CITY OF ALBUQUERQUE

November 7, 2013

Re: Drainage Master Plan for the Mirehaven Master Planned Community and Pulte@ Mirehaven Phase 1 Drainage Report and Grading and Drainage Plan Engineer's Stamp Date 10-11-13 (H09D017B)

MIREHAVEN ARROYO
IMPROVEMENTS
HEC-RAS PLAN
07/2015

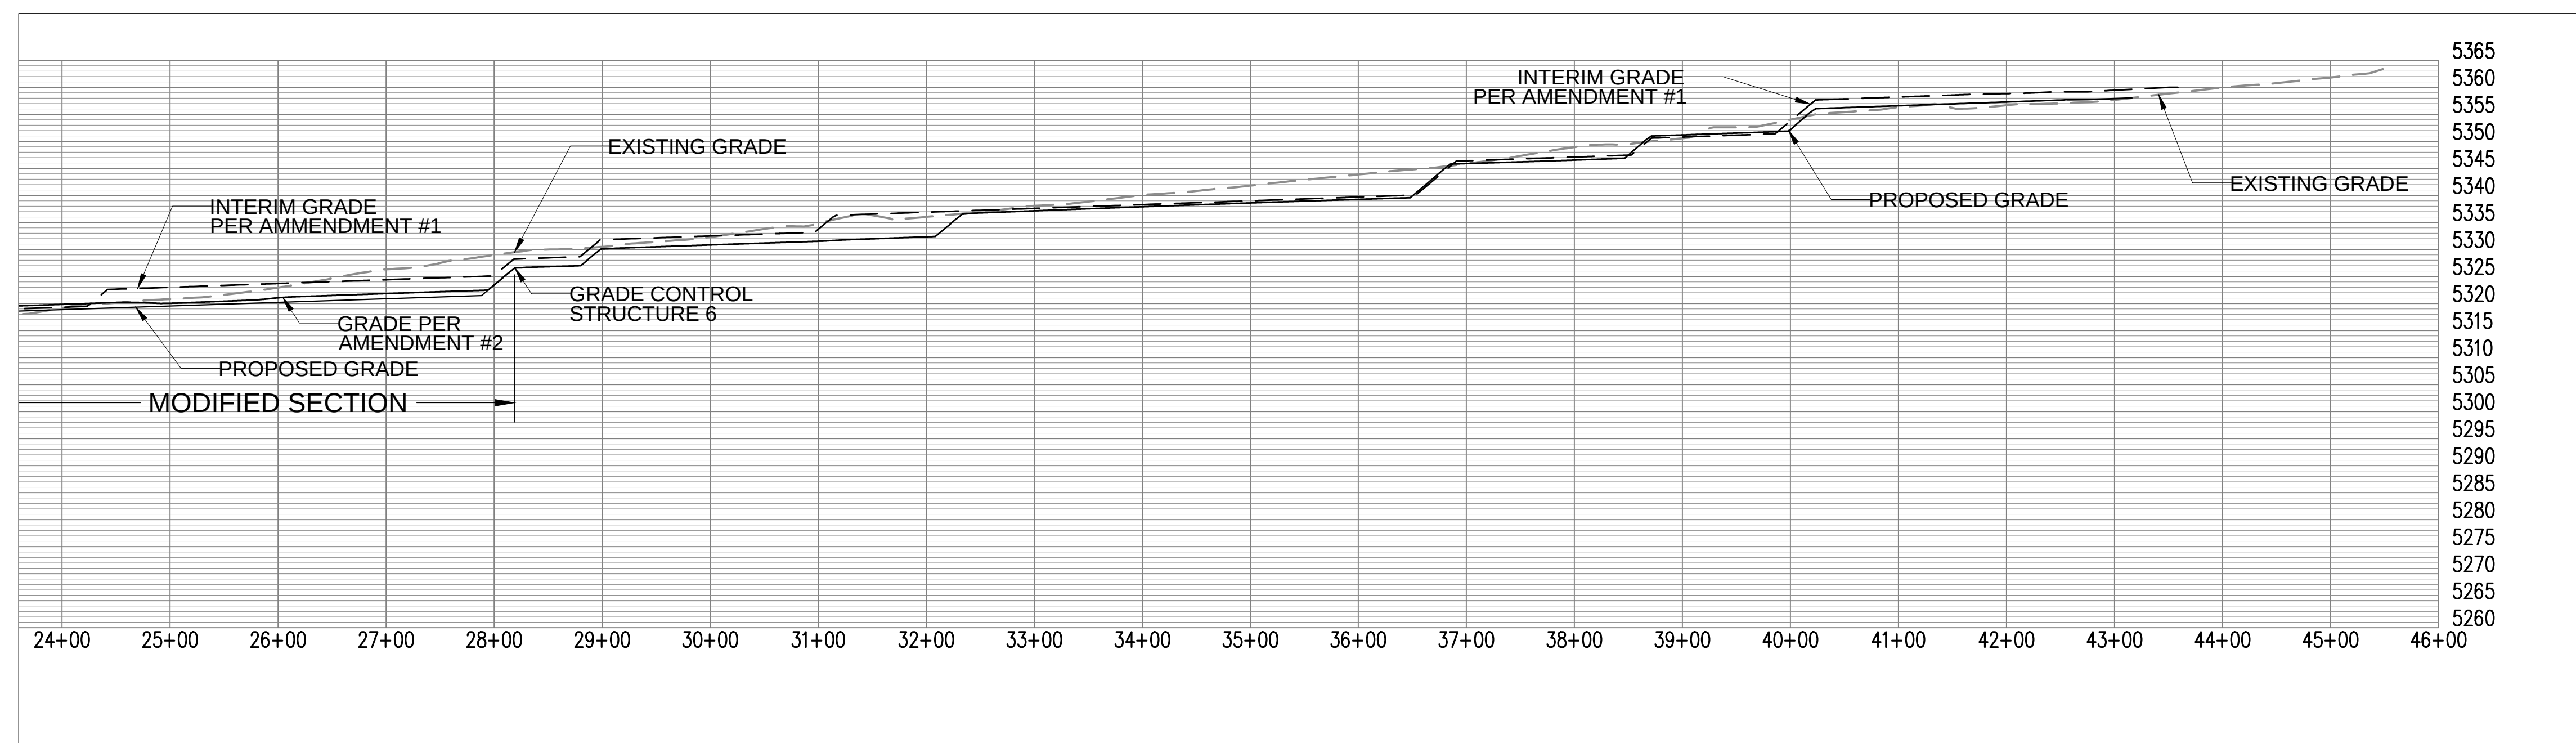
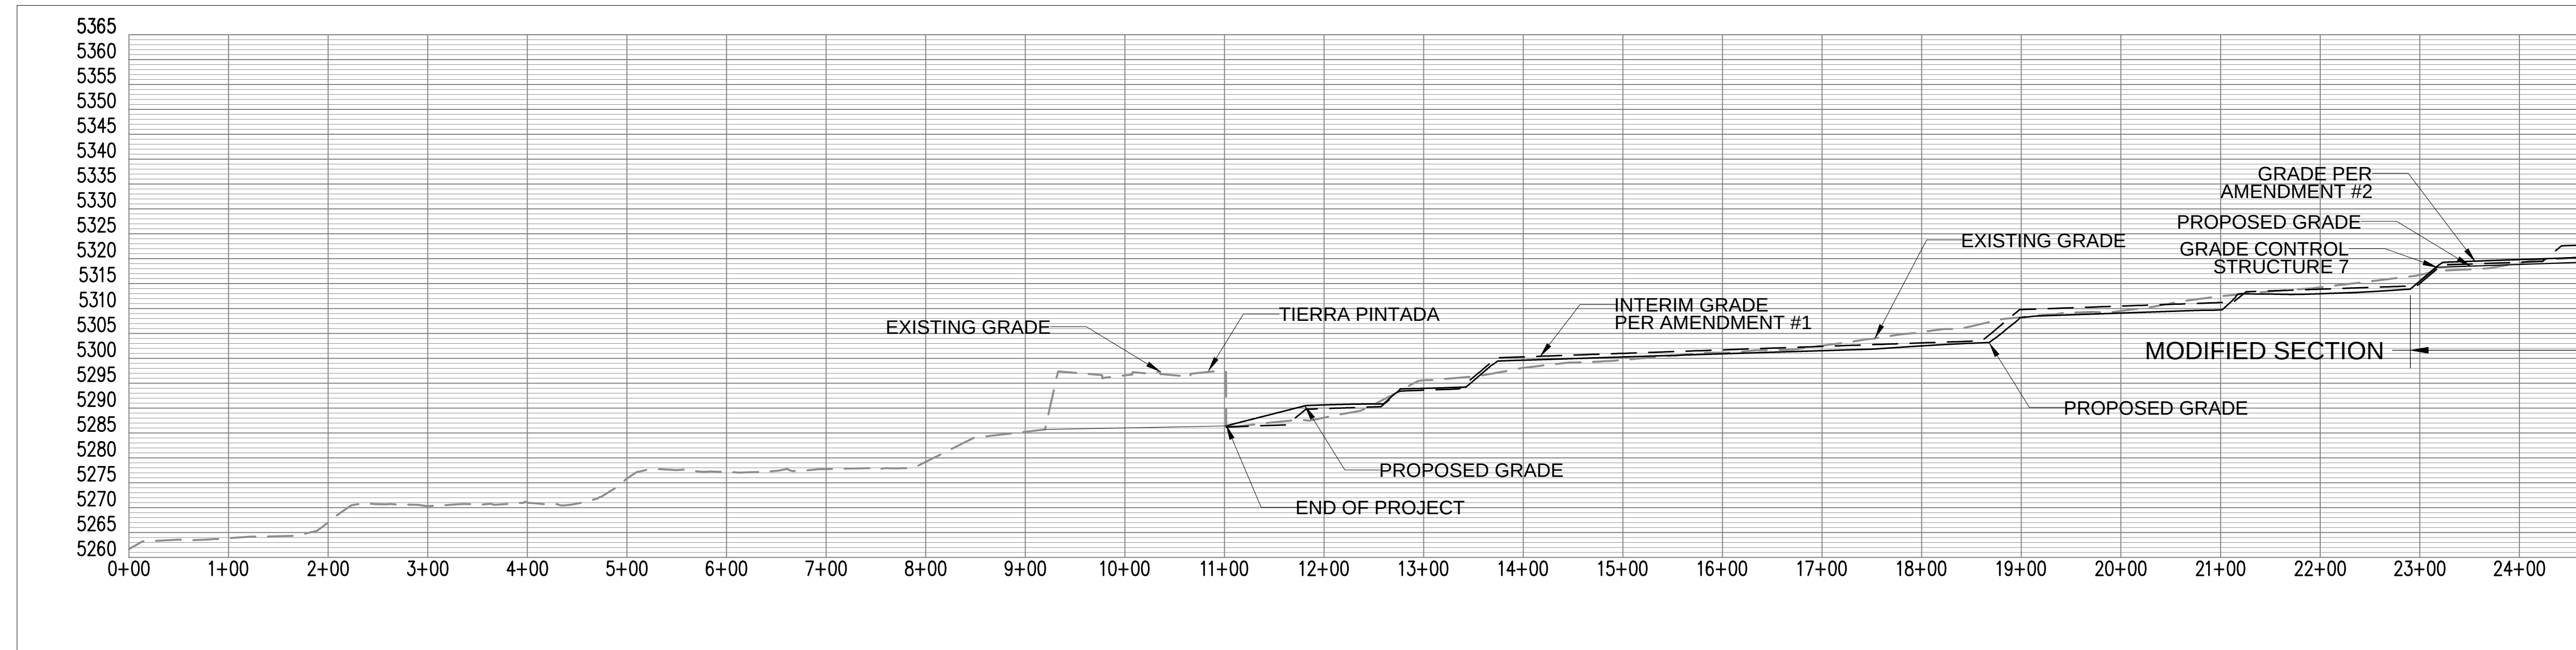
19. At this point in the process, Hydrology needs to determine the appropriate easement/right of entry width of the channel. Since a plan view exhibit showing river stations was not provided, Provide HEC-RAS sections at the following station locations from Exhibit 7: 41+75, 32+50, 32+00 (grade control structure), 30+00, 23+75 (just upstream of crossing), 23+50 (crossing), 22+00, 20+00, 13+00, 12+00, 11+50 and 11+00. It is acceptable to provide sections at a close River Station (e.g. 1301.528 for 13+00)

MIREHAVEN ARROYO IMPROVEMENTS PLAN

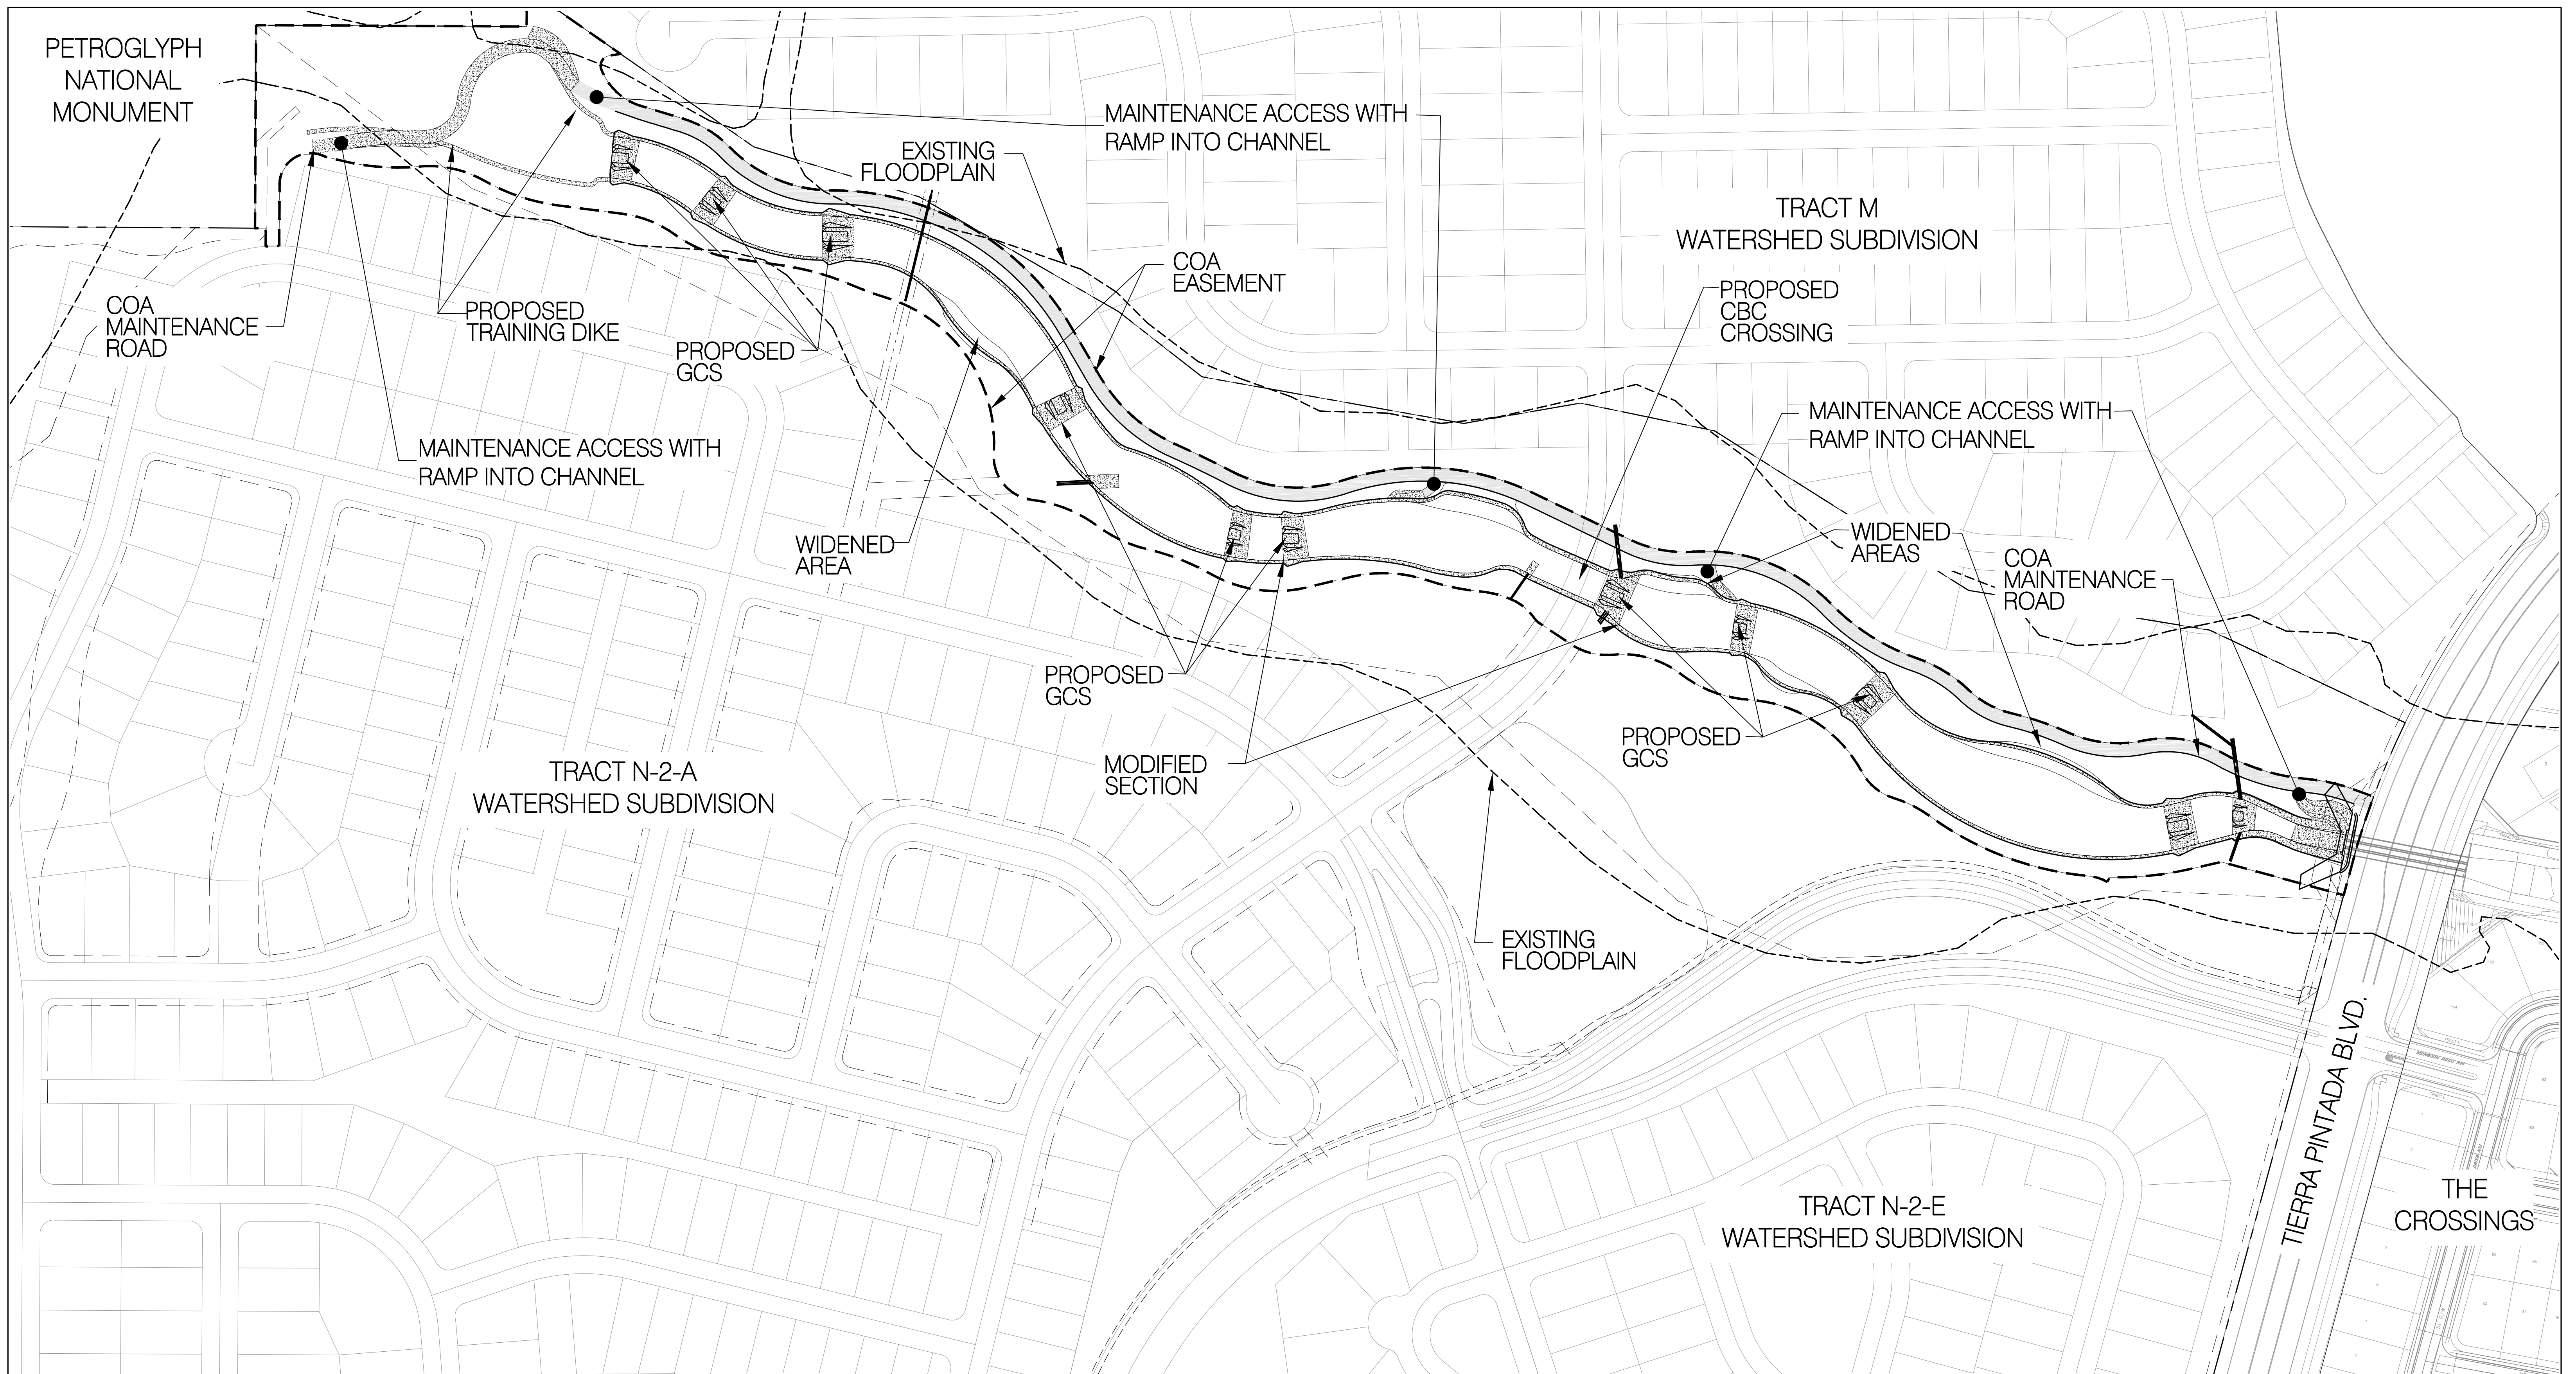
13. The storm drain network plan appears to only support Pulte@Mirehaven Phase 1. As a drainage master plan for the site, it should show the storm drain in Basin A as well as the channel on the west side of the project.

15. The channel walls should not be constructed of CMU (p.7) and the vertical concrete portion of the channel should provide a minimum of 1' of freeboard.
